**KIRKLEES METROPOLITAN COUNCIL  
INVESTMENT & REGENERATION SERVICE**

**DELEGATED DECISION TO DETERMINE PLANNING APPLICATIONS**

Reference No:	<b>2023/62/91649/E</b>
Site Address:	11, Wood Street, Skelmanthorpe, Huddersfield, HD8 9BN
Description:	Demolition and rebuild boundary wall
Recommending Officer:	Nicole Helliwell

### **Officer Report**

Tree Constraints Plan
11 Wood Street, Skelmanthorpe

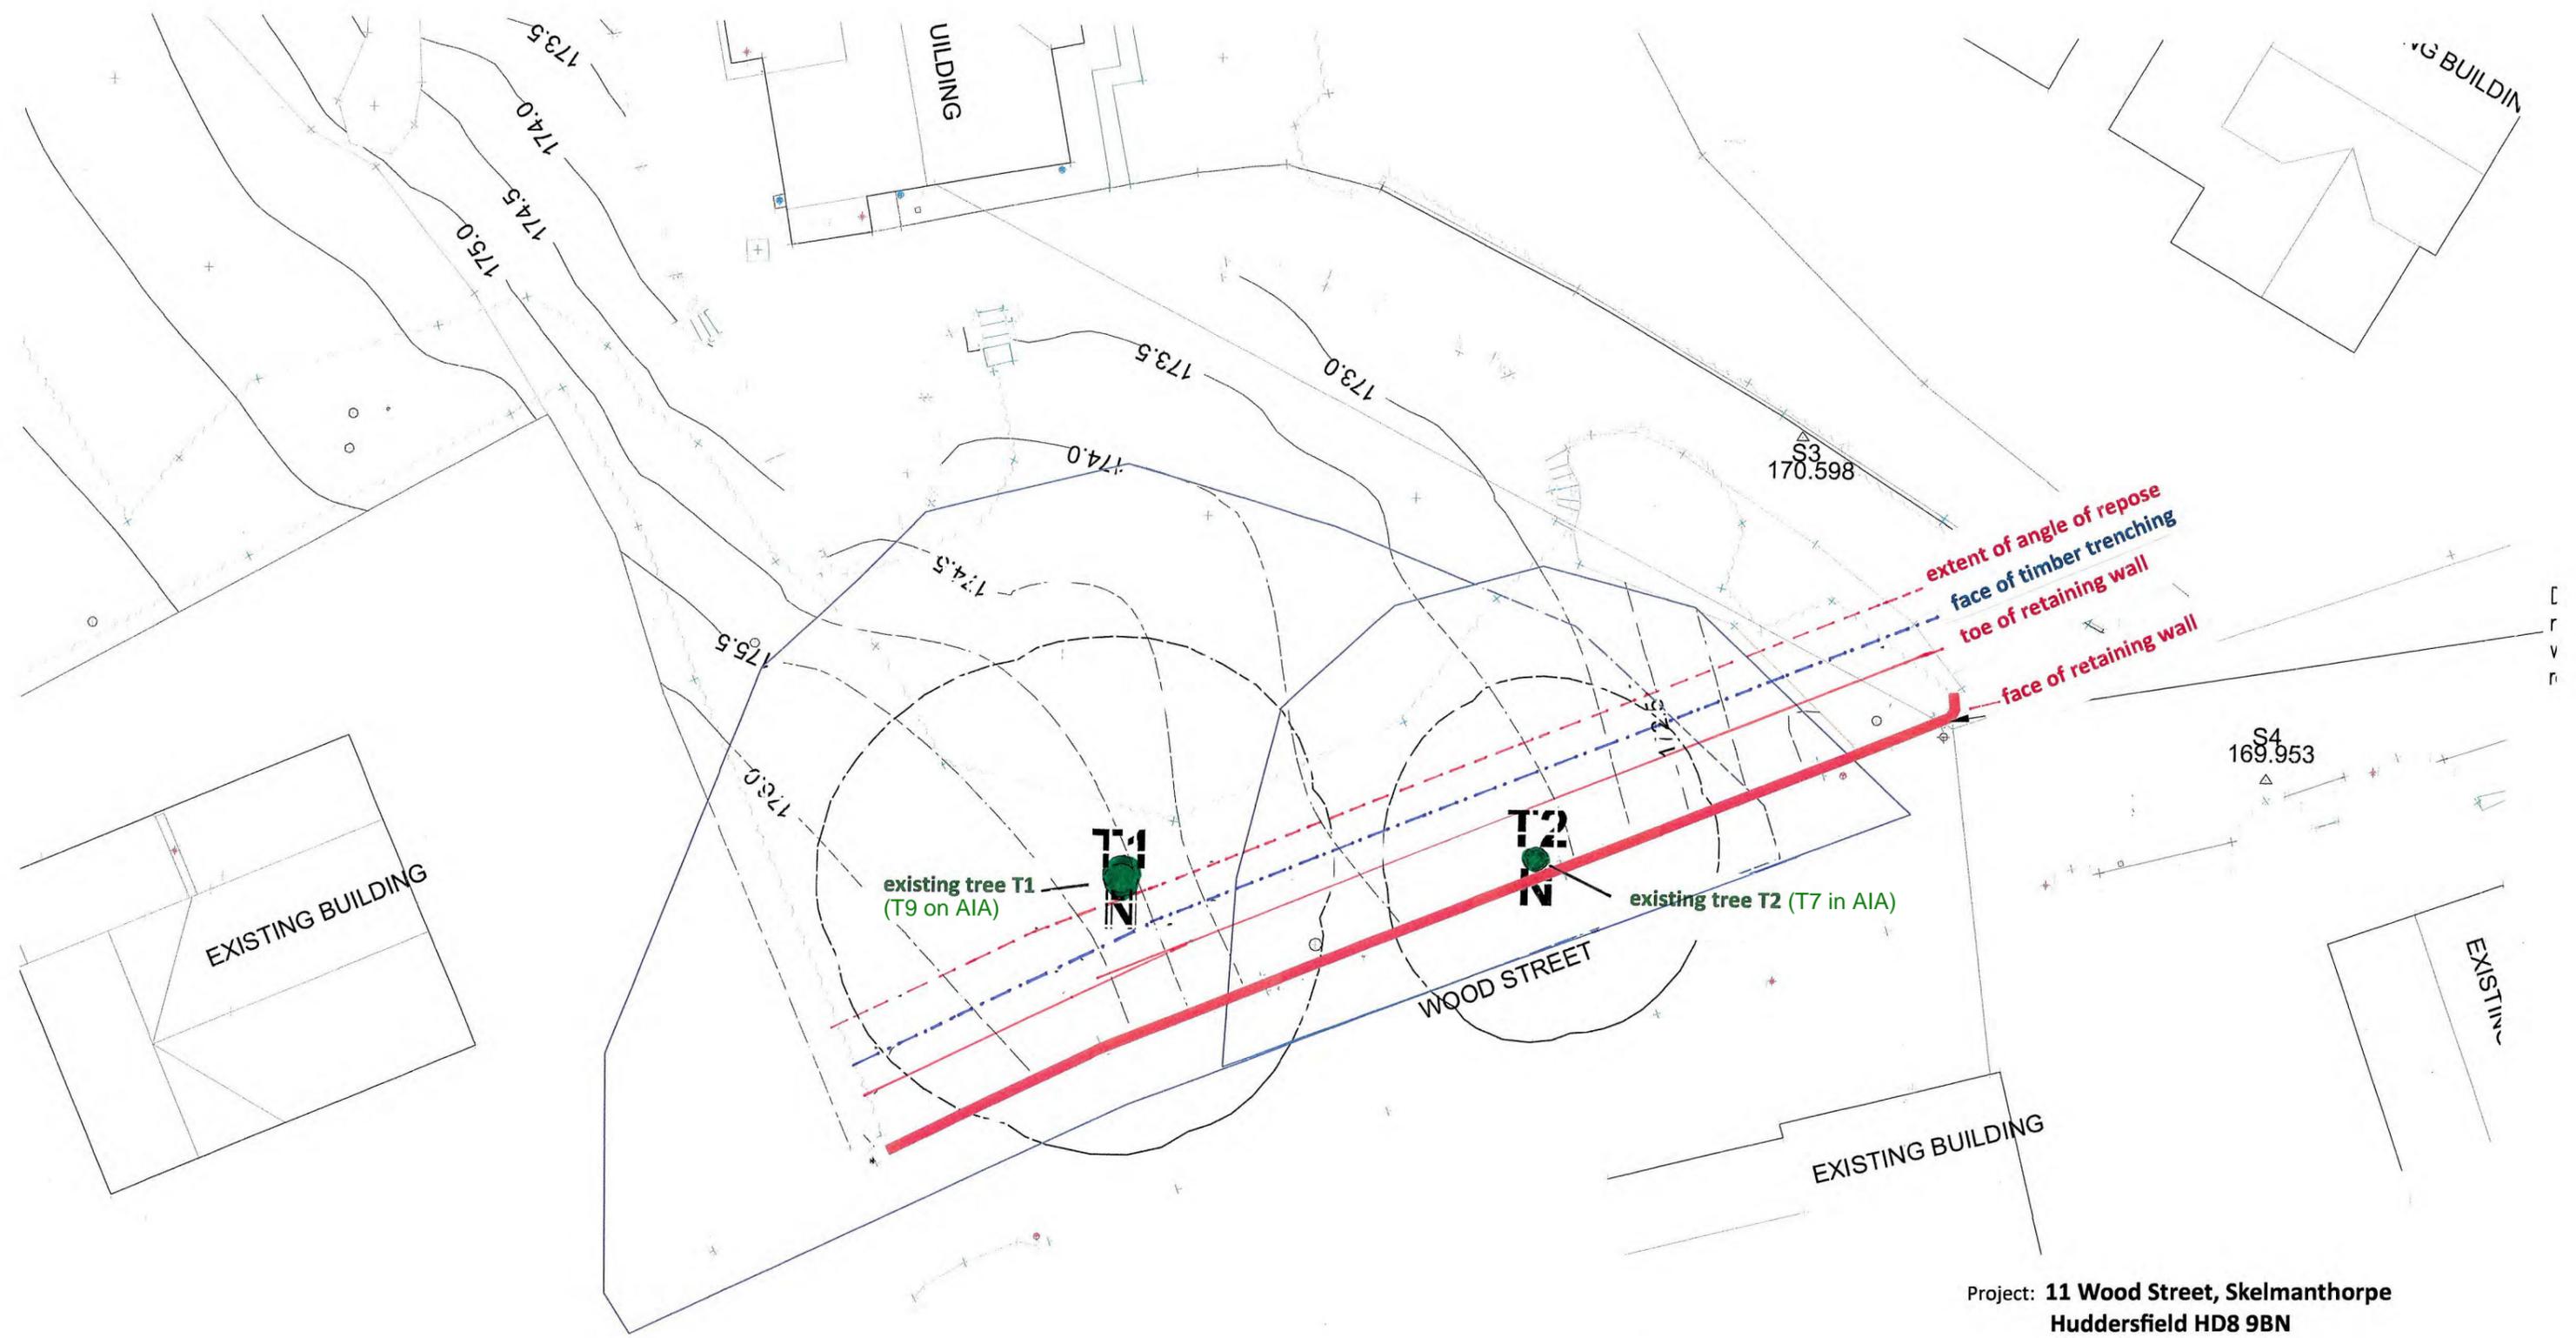
The Arboricultural Impact Assessment argues that the trees subject to the TPO (T7 and T9 in the report) are justifiable Arboricultural Management losses on the grounds of the present and increasing conflict they pose to the neighbouring retaining wall and public highway. And as a result, categorises them as “U”, Those in such a condition that they cannot realistically be retained as living trees in the context of the current land use for longer than 10 years, due to the alleged tree related hazard (BS5837:2012 Paragraph 4.5.8). In addition to guidance within BS5837 in Annex A Table A1 that trees with a growth potential above 600mm stem diameter at 1.5m height should be planted no closer than 2m to a masonry boundary wall. The location of trees T1, T3, T5, T6, T7 and T8 would appear to conflict with this guidance.

For the assessment of T7, KC trees have noted the justification. Its position in relation to surrounding structures does limit its remaining years to enough to give it a lesser tree quality assessment. However, the assessment of T9 being category C seems to be unnecessarily downgraded. The tree is double the 2m recommended minimum distance to masonry boundary wall and from the survey schedule it is a “Visually prominent tree” that “exhibits good vitality and vigour with no major defects evident save for minor snags and dead wood”.

KC Trees are not convinced that T9 should be included within a similar comparison as T7, in that a tree related hazard (BS5837:2012 Paragraph 4.5.8) or lumping it in with T7 should downgrade it. Trees of generally high quality and/or value which have a defect or defects that do not reduce their retention span below the suggested 40 year threshold which seems to be the case for T9, should be placed in category A and should not be downgraded as a result of minor imperfections.

Title: **Retaining Wall – Construction Method
Plan**

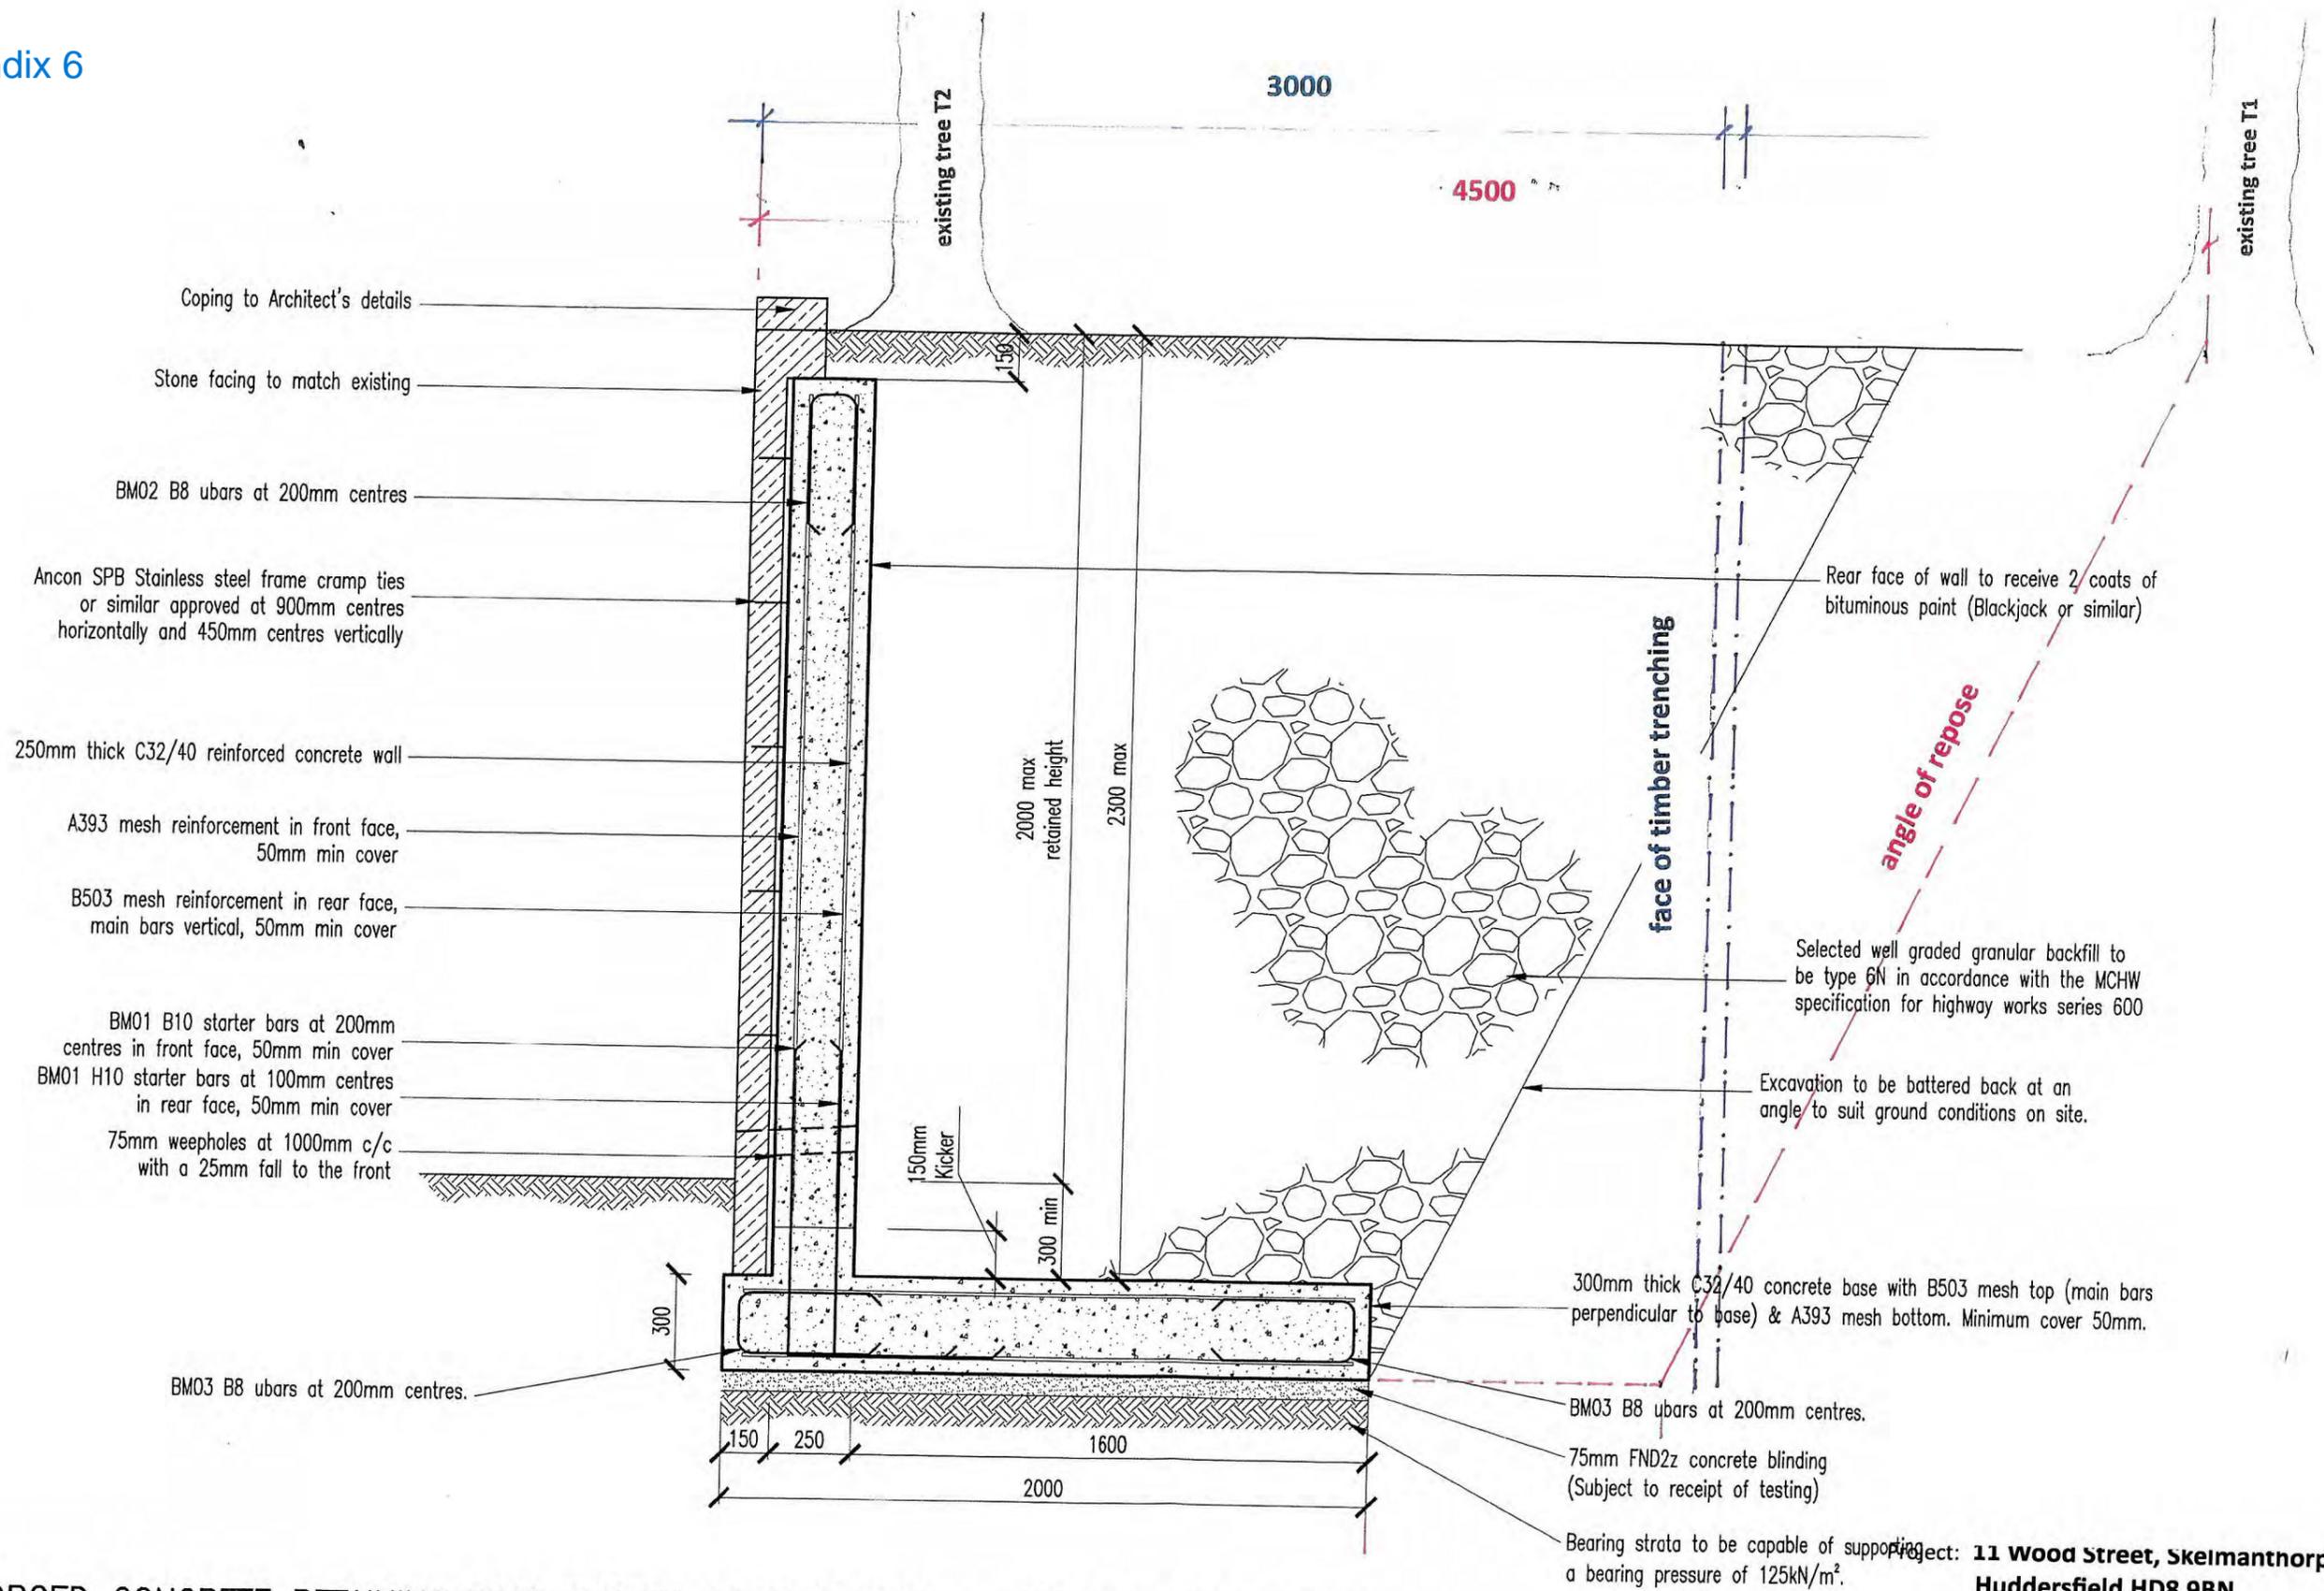
The proposal would not intensify the domestic use at the dwelling and would not affect the existing parking arrangements on site. KC Highways Structures were formally consulted as part of the application and have recommended that a pre-commencement condition is imposed should the application be approved. The condition requires the demolition details of the existing retaining wall cumulatively with the design and construction details of the proposed retaining wall to be submitted prior to development commencing on site.

Concerns were also expressed regarding how the proposed masonry faced retaining wall would tie into the existing retaining walls. However, this would be a private matter and would not be a material planning consideration.
